CITY OF MERCER ISLAND

Pre-Application Meeting (PRE23-041 – Location 3)

Site Location:	5801 Island Crest Way, Mercer Island, WA 98040	Parcel Number	1924059013
Lot Size:	38.36 Acres	Zoning:	R-9.6 (Single Family)
Brief Project Description:	The City of Mercer Island Public Works Department (Applicant) is proposing installation of data collection equipment at 5801 Island Crest Way (Island Crest Park) to support the Mercer Island Meter Replacement Program.	Documents Provided:	<ol style="list-style-type: none">1. Pre-Application Meeting Request Form2. Cover Letter3. Application Questions4. Project Description5. Site Plan6. Drawing7. Tree Inventory Worksheet8. Public Participation Plan
Applicant Information:			
Name: Alaine Sommargren, City of Mercer Island Public Works	Email: alaine.sommargren@mercerisland.gov	Phone: 206-275-7879	
Second Pre-application Meeting Required:	Choose an option	Click for explanation if necessary

**Figure 1: Map showing proposed base station locations**

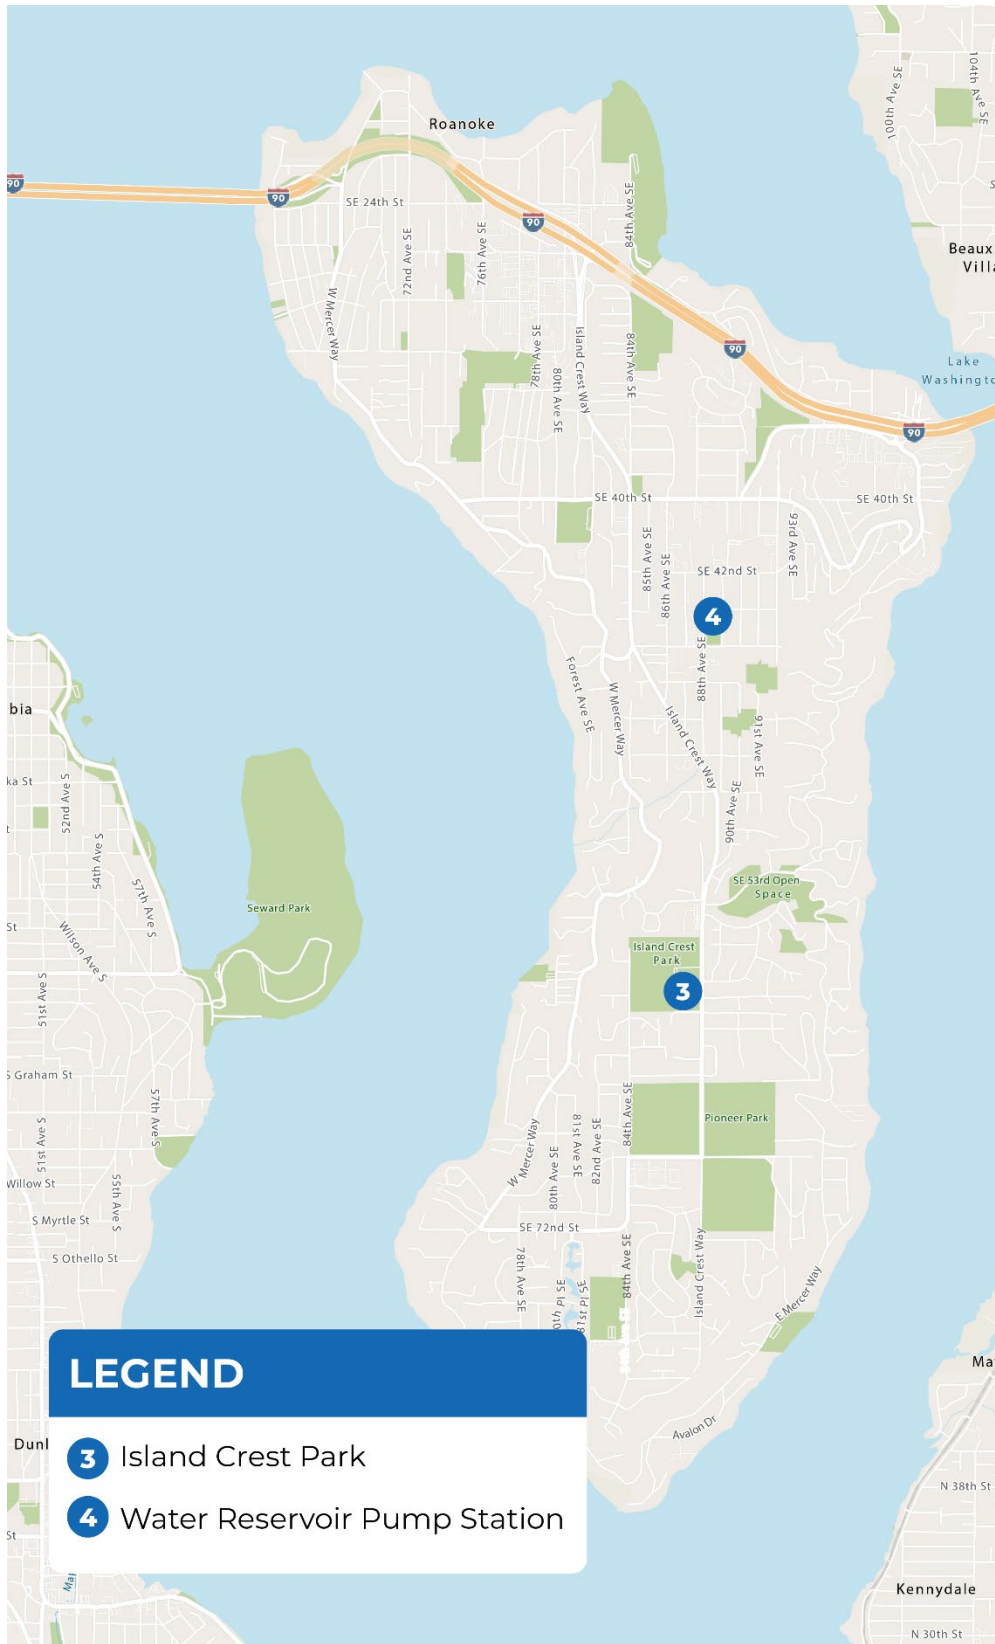
3. The location is shown on Figure 1 is on the City's private property, and the proposal will require building and electrical permits for the work.
4. A statement of risk conforming to the MICC section above is required specific to this scope of work. (the location is mapped as a seismic liquefaction hazard). Your geotechnical engineer may be able to base the statement on available site investigations. If your Geotech doesn't have an extensive history of working with the Mercer Island Geologically Hazardous Areas codes, please have them reach out to Gareth.reece@mercerisland.gov.
